Subject: Former Grove URC Chapel Oxford Road, Gomersal, Cleckheaton, BD19 4JY Application 2023/90073
Date: 21 February 2023 09:54:55

Thankyou for your consultation, received via the Joint Committee casework hub.

Only figured dimensions should be used.
 Scaled dimensions should be checked with the Architect.
 This drawing together with the design, is the property and copyright
 of the Architect and must not be reproduced without written
 permission

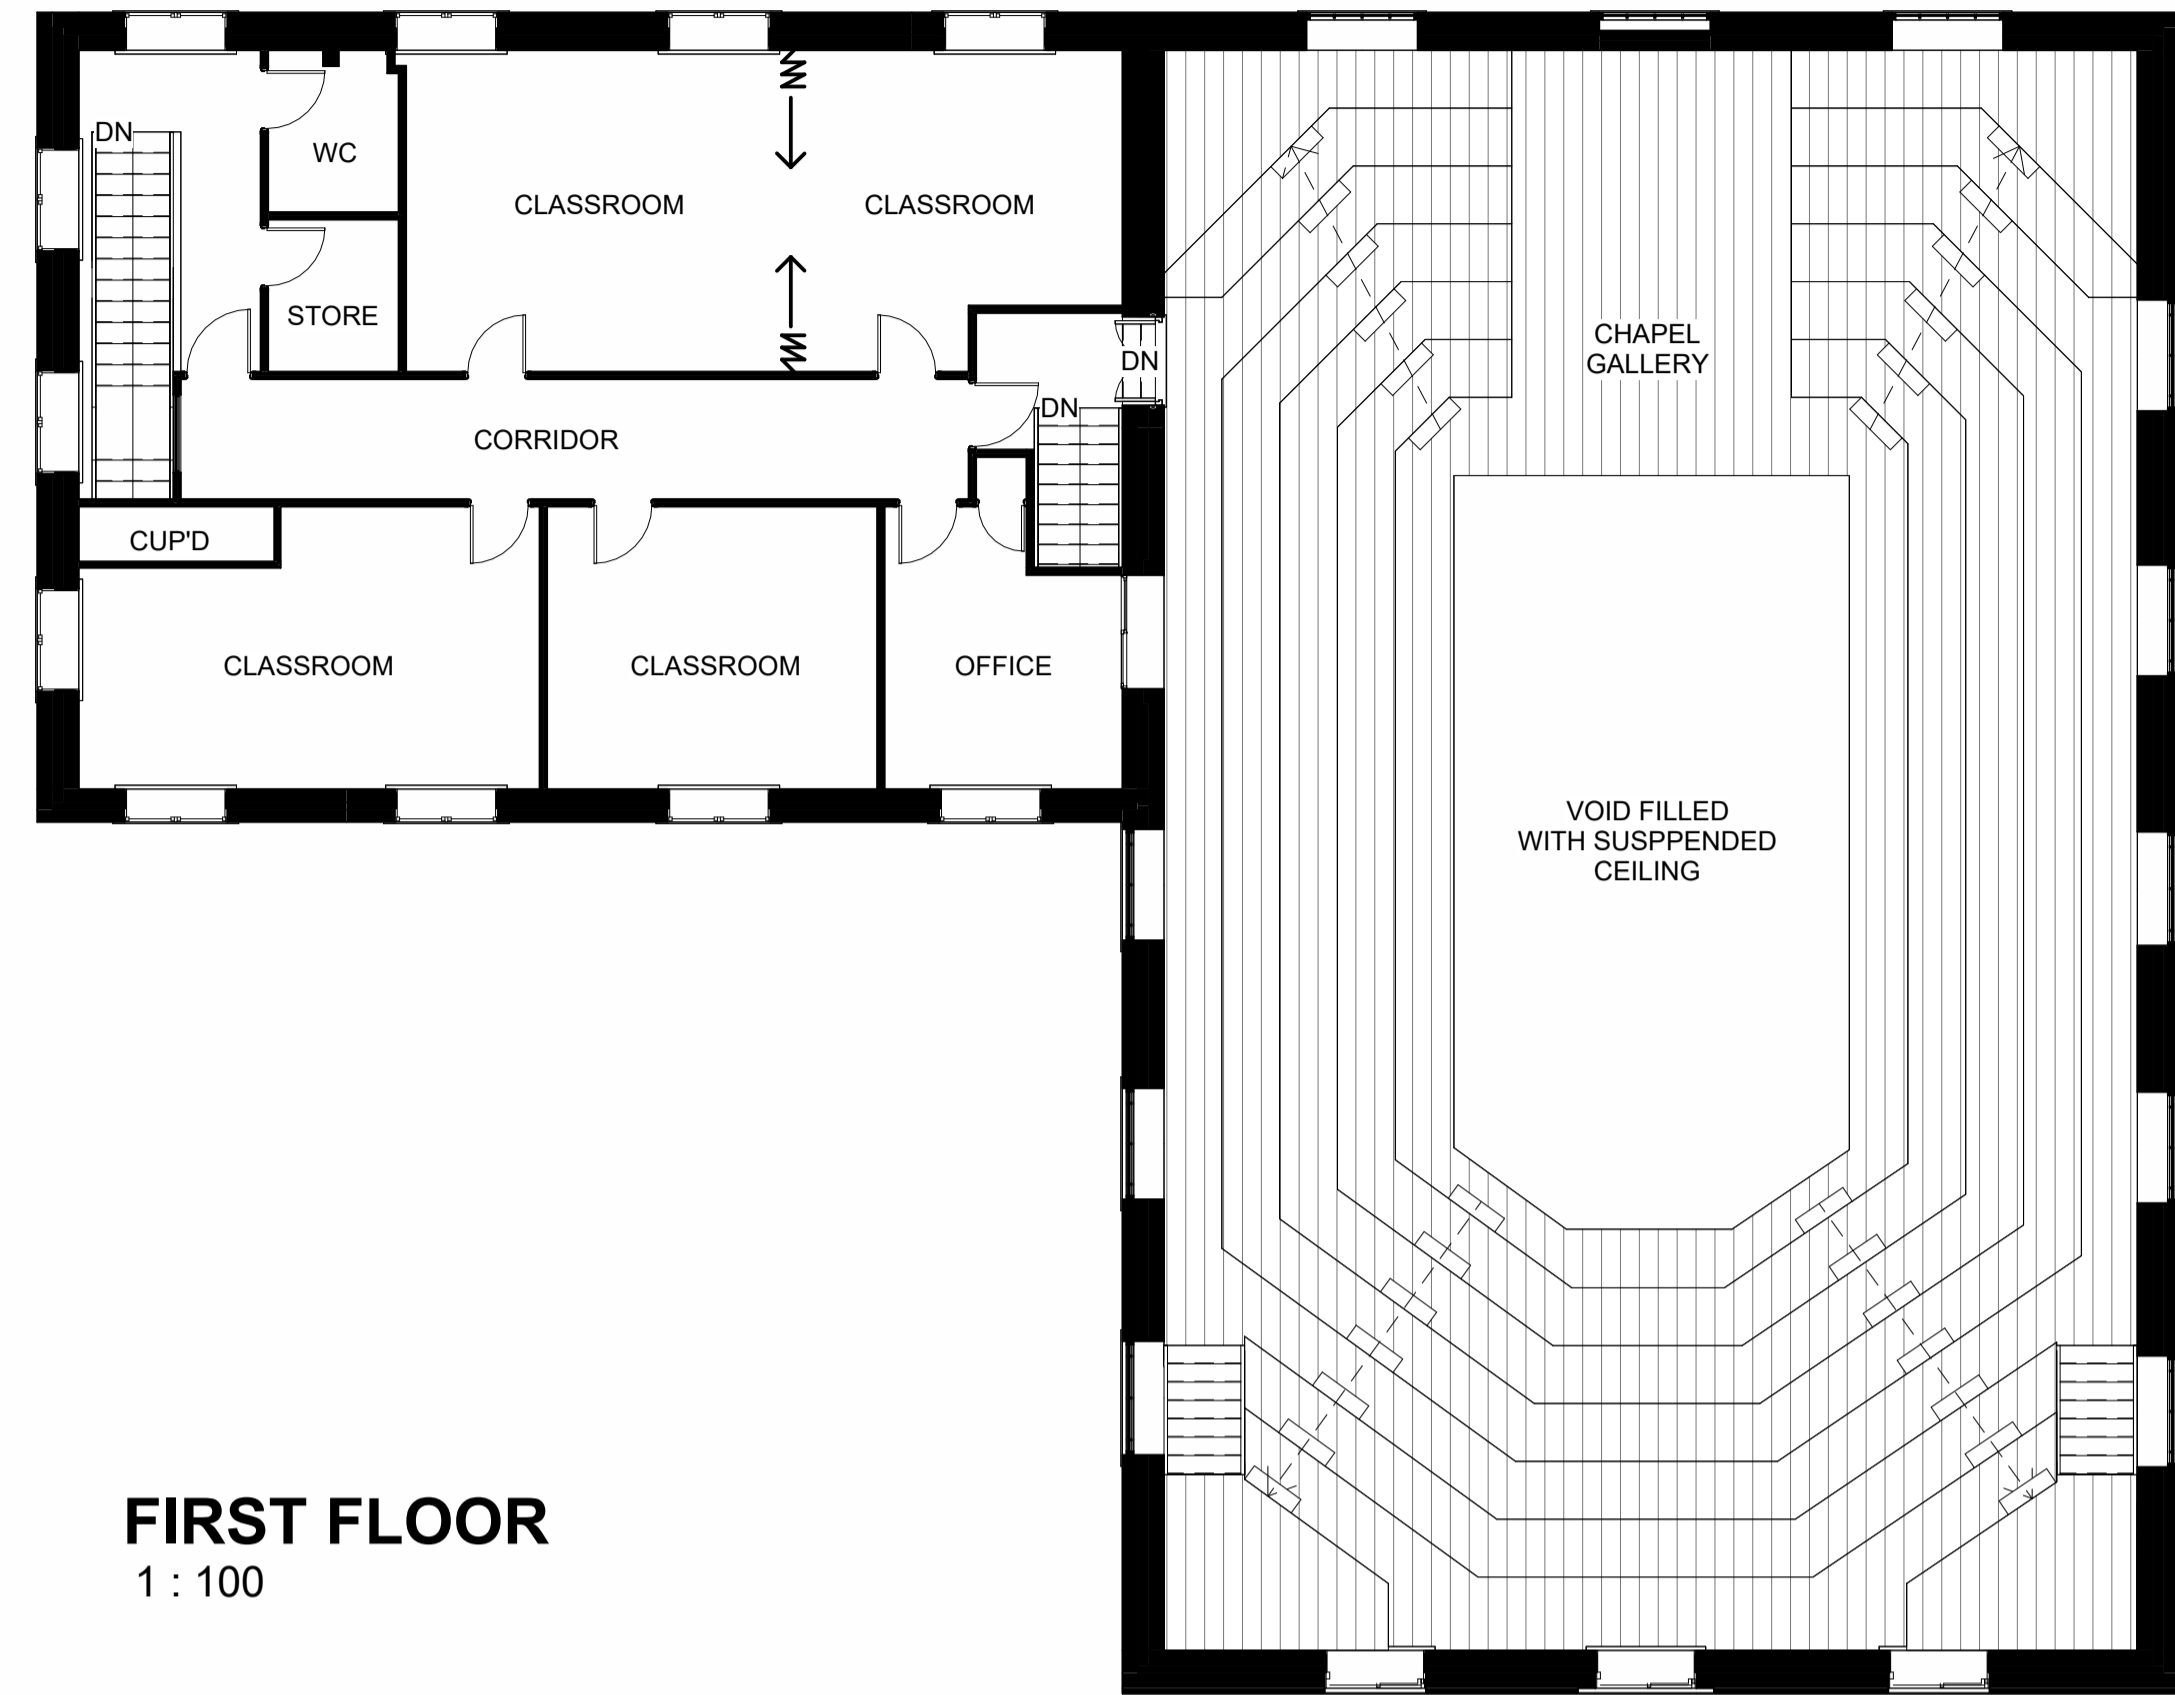
We must express considerable disappointment at the intensity of the conversion. The insertion of as many as 10 residential units effectively breaks up the historic interior.

At 4.16 the Heritage Statement lists some possible ameliorations but the scale of the drawings is such that it is impossible to test how many, if any, have been taken up.

1. It needs to be established first that a use is not possible which works with the character of the interior as a purpose-built auditorium (with the removal of the inserted floor). How wide has been the marketing ?
2. Secondly why is it not possible to limit the intense conversion to the Sunday School, which is the lesser and more altered of the two listed buildings ?
3. Why must there be so many units in the chapel interior ? The lobby and the gallery stairs are retained but very little else. Is it not possible to provide more substantial but fewer units in the chapel thus reducing the need for so many subdivisions ?
